From: E Visram [REDACTED]
Sent: 30 July 2015 12:13
To: Ross Leal
Subject: Planning Application 31 Sea Way Reference M/56/15/HH

I have seen on the Council's web site the letter dated 27 July from Martin Helyer that accompanied the plans that are said to illustrate the position of the drains

GROUND FLOOR
1.100

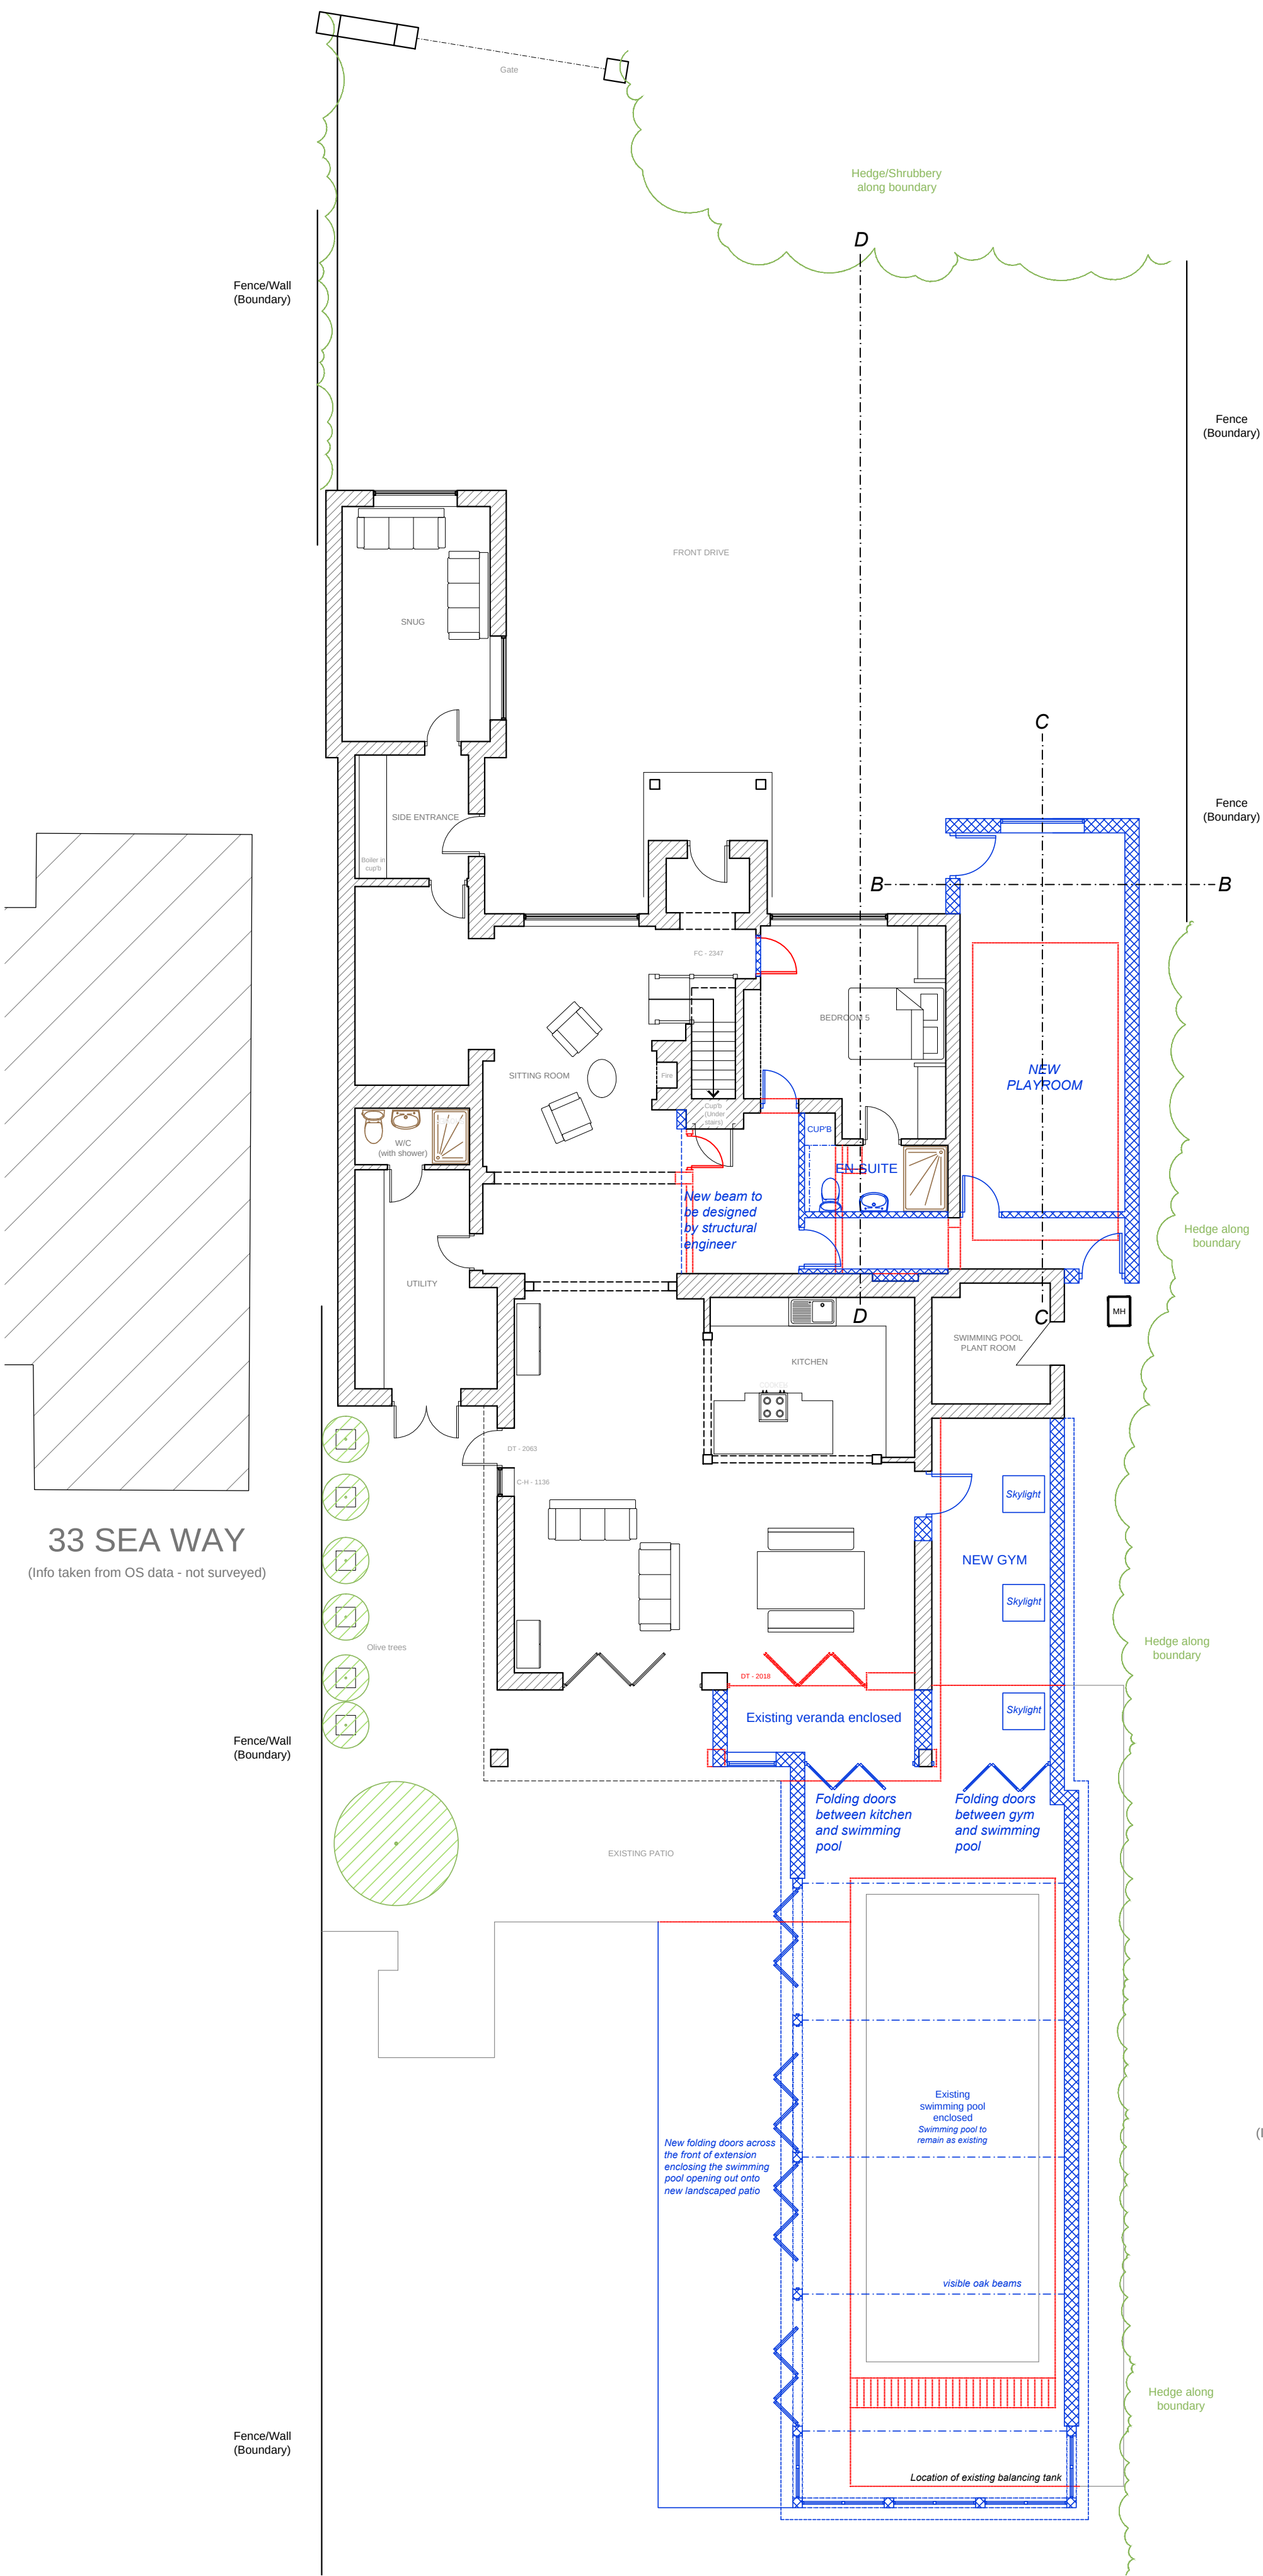
The proposed extensions do not appear to have taken any account of the drains existence or the requirement to maintain or replace the drain. From a simple visual inspection of the location of the manholes they appear to be approximately 1.5 to 1.75 meters from the boundary, which places them directly under the foundations of the extensions. The proposal should therefore be refused to allow working area provision for maintenance or replacement of the drains.

Surface Water Drain
Sea Way
Middleton-on-Sea

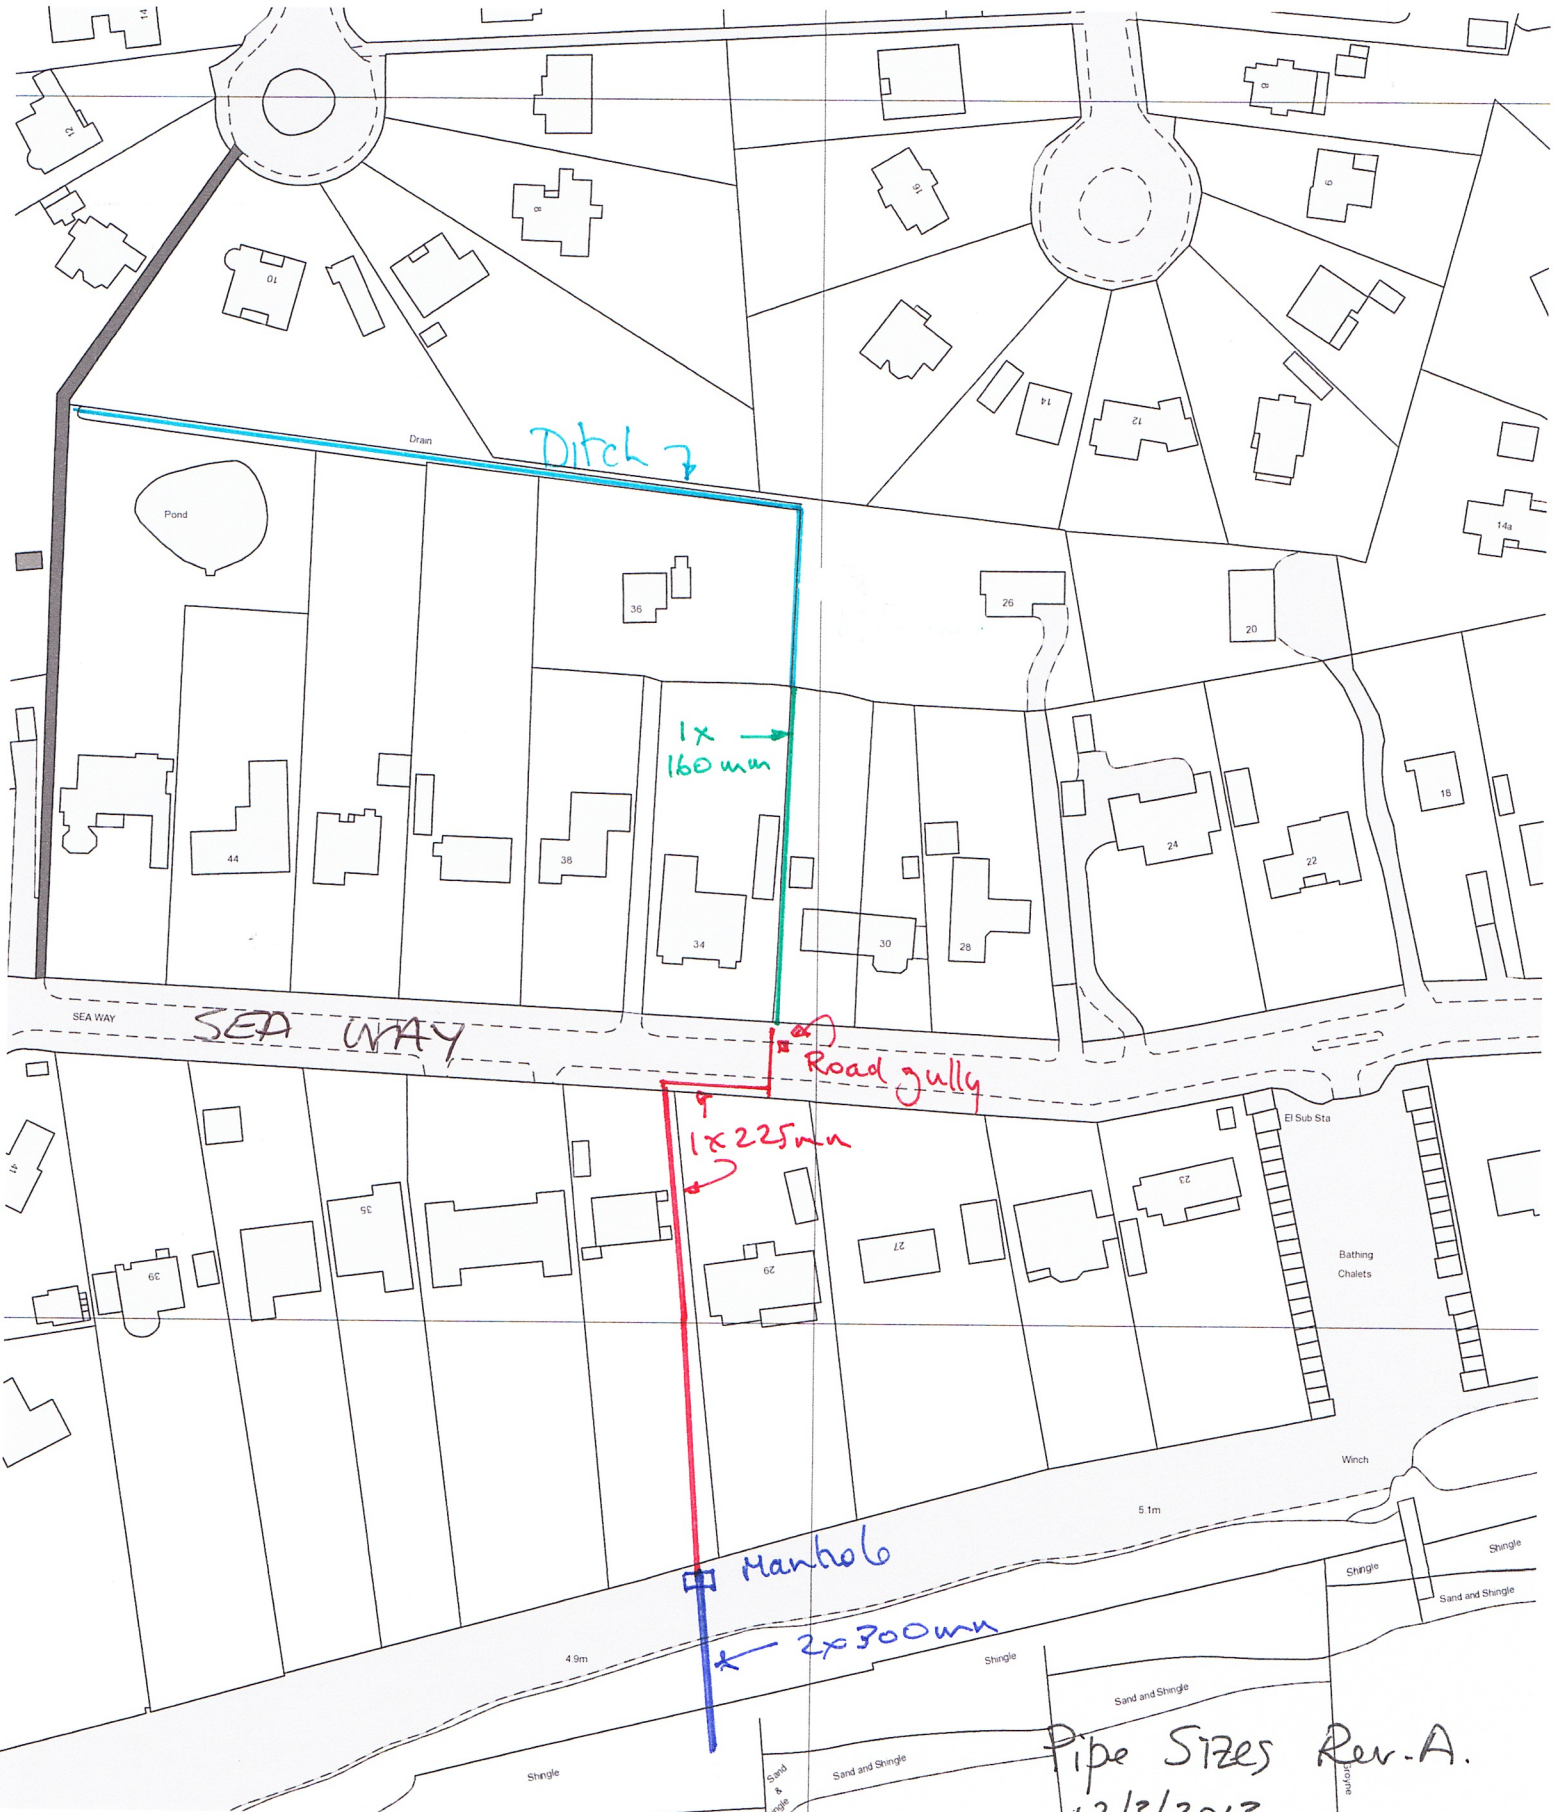
We request that you kindly do not rely on the drawings submitted by Martin Helyer mentioned above as these may or may not show accurately where the drain is and Martin Helyer submit an accurate survey showing where the drain is and relation to the proposed extensions and its foundations.
